Department of Planning, Housing and Infrastructure

Our ref: Julius Avenue Data Centre (SSD-80018208)

Subject: Julius Avenue Data Centre – Additional matters for Submissions Report

Figure 3. Location of STSS (Source: Greenbox Architects, 2025)

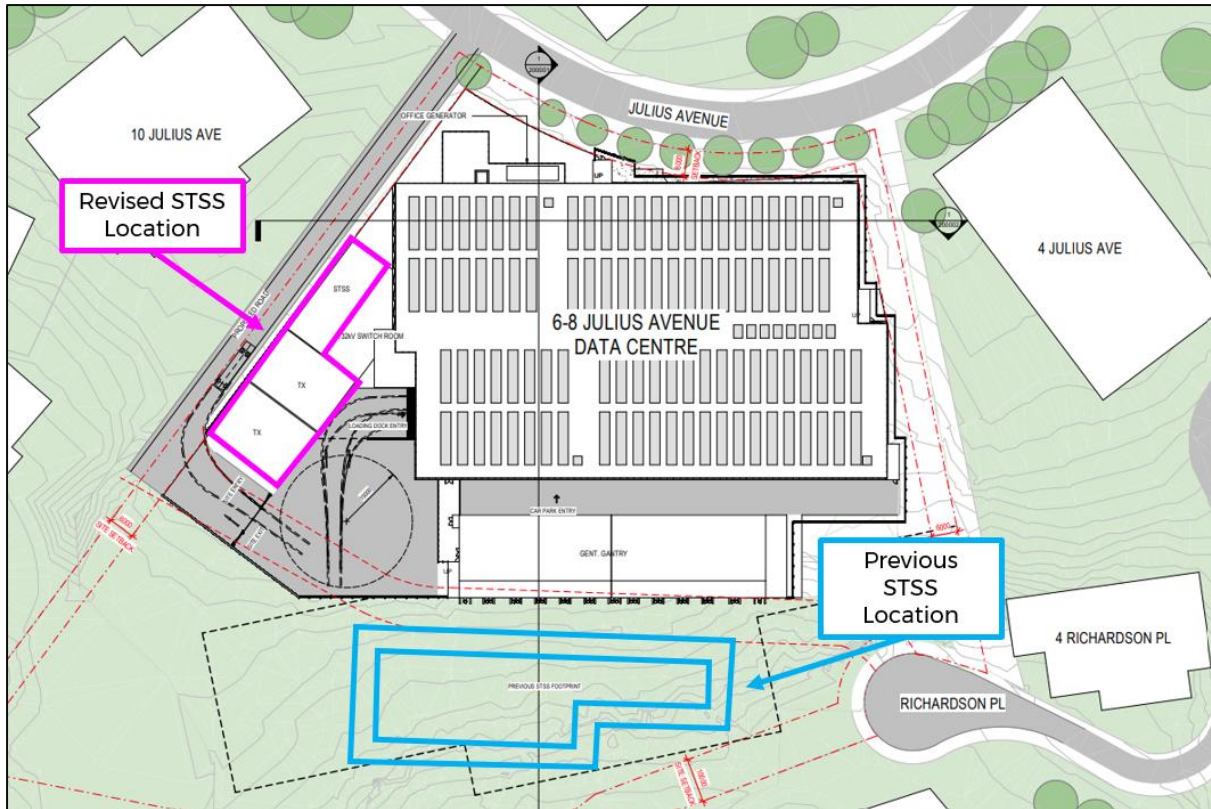
1. The Department echoes the concerns raised by City of Ryde and the CPHR Group regarding the development's footprint. The Department notes that key elements of the proposal, including the new internal road connection with Richardson Place, the sub-transmission switching station (STSS), and the enclosed generator gantry at the rear of the data centre building, encroach into the prescribed landscape setback area identified in Figure 37b of the Macquarie Park Design Guide.

15. The EIS cites a STSS with a capacity of 180 MVA, whereas the planning advice letter from Ausgrid, located in Appendix 29 of the EIS, indicates an ultimate demand of 240 MVA. Further information is required to clarify the staging of the proposed development and its ultimate power consumption.

20. The Erosion and Sediment Control Plan (241920-TTW-00-DR-CI-02101-B) shows an indicative location for an earth basin that appears to overlap with the footprint of the STSS. Please clarify how this basin will function during construction.
